# Gatwick Airport Northern Runway Project

Statement of Common Ground Between Gatwick Airport Limited and Surrey County Council

DATE: MARCH 2024

Application Document Ref: 10.1.8

Figure 1: Location of Contractor Compounds

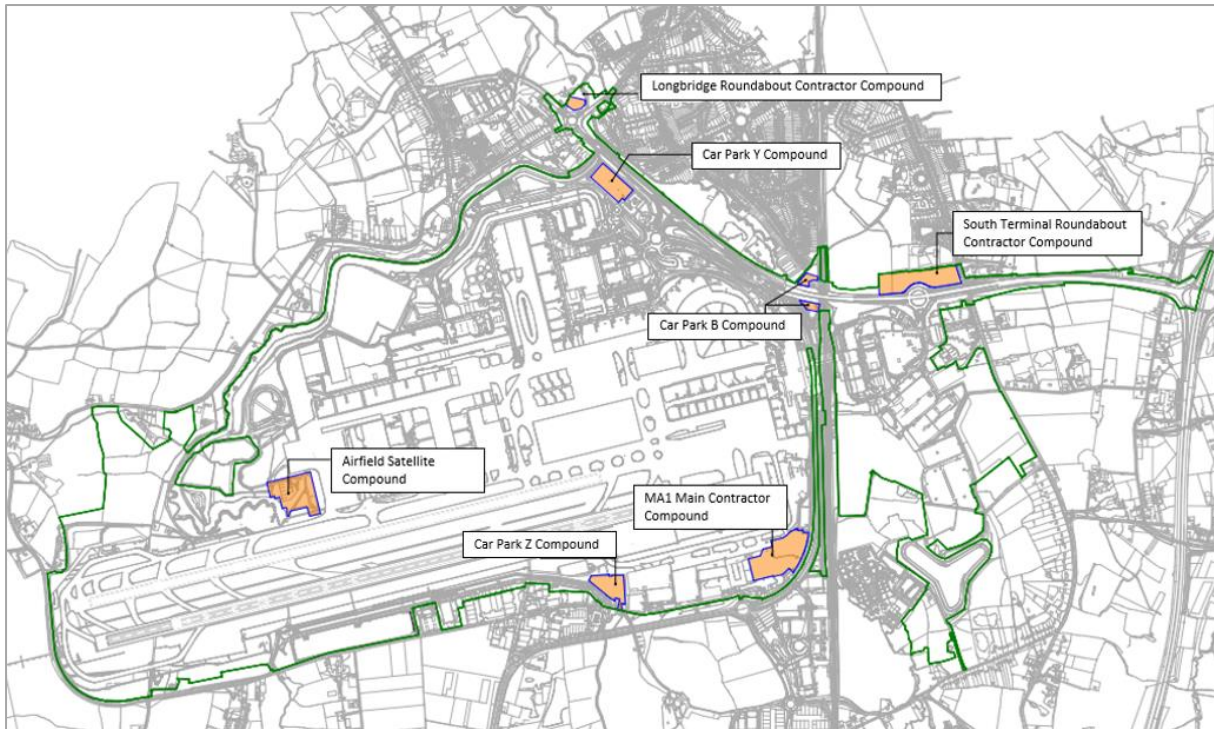
2.5.1.3	Securing mitigation	<p>The entrance to the Longbridge Roundabout compound is not defined.</p> <p><b>Updated position (Deadline 1):</b> The existing access track is inappropriate in terms of width, geometry, its lack of visibility at its crossing of the shared cycle/footway and proximity with the pedestrian signals at the approach to the roundabout. We would expect to see right turns in to the site only allowed via u turns at the Tesco roundabout (ie only left in and left out).</p>	<p>Temporary construction compound activities associated with the proposed permanent works will be conducted within Church Meadows, using an access road shared with Dairy Farm.</p> <p>Construction vehicle access to and from the temporary construction compound at Longbridge Roundabout will be via the existing access track off the eastern side of A217, located approximately 45 metres north of the Longbridge roundabout.</p>		Under discussion

2.5.1.4	Securing mitigation	<p>SCC is concerned that separate entrances to the South Terminal compound are proposed for HGVs (from the roundabout) and private vehicles (from Balcombe Road). This implies that an extended journey on the local road network is required.</p> <p><b>Updated position (Deadline 1):</b> The report states that Balcombe Road will also be used by private vehicles - Buildability Report Part B para 7.4.6 states "Direct access to Balcombe Road for only workforce private cars will be provided. This access will also be used during the replacement of Balcombe Road Bridges that are part of the South Terminal Roundabout works. The access would also allow limited early access to the land to commence construction of the compound prior to access off the South Terminal Roundabout.</p>	<p>The proposed construction methodology and construction vehicle routes is detailed in ES Appendix 5.3.1. Buildability Report Part B, and the Outline Construction Traffic Management Plan.</p> <p>All construction vehicle access will be through the South Terminal Roundabout. Additionally, a separate access route from Balcombe Road is planned specifically for constructing the compound, which includes building the ramps and connections to the South Terminal Roundabout. This access will also facilitate the Balcombe Road Bridge Replacement and the associated embankment widening works.</p>	<p><b>ES Appendix 5.3.1 Buildability Report Part B Part 1</b> <a href="#">[APP-080]</a></p> <p><b>ES Appendix 5.3.1 Buildability Report Part B Part 2</b> <a href="#">[APP-081]</a></p> <p><b>ES Appendix 5.3.2: Annex 3 – Outline Construction Traffic Management Plan</b> <a href="#">[APP-085]</a></p>	Under discussion
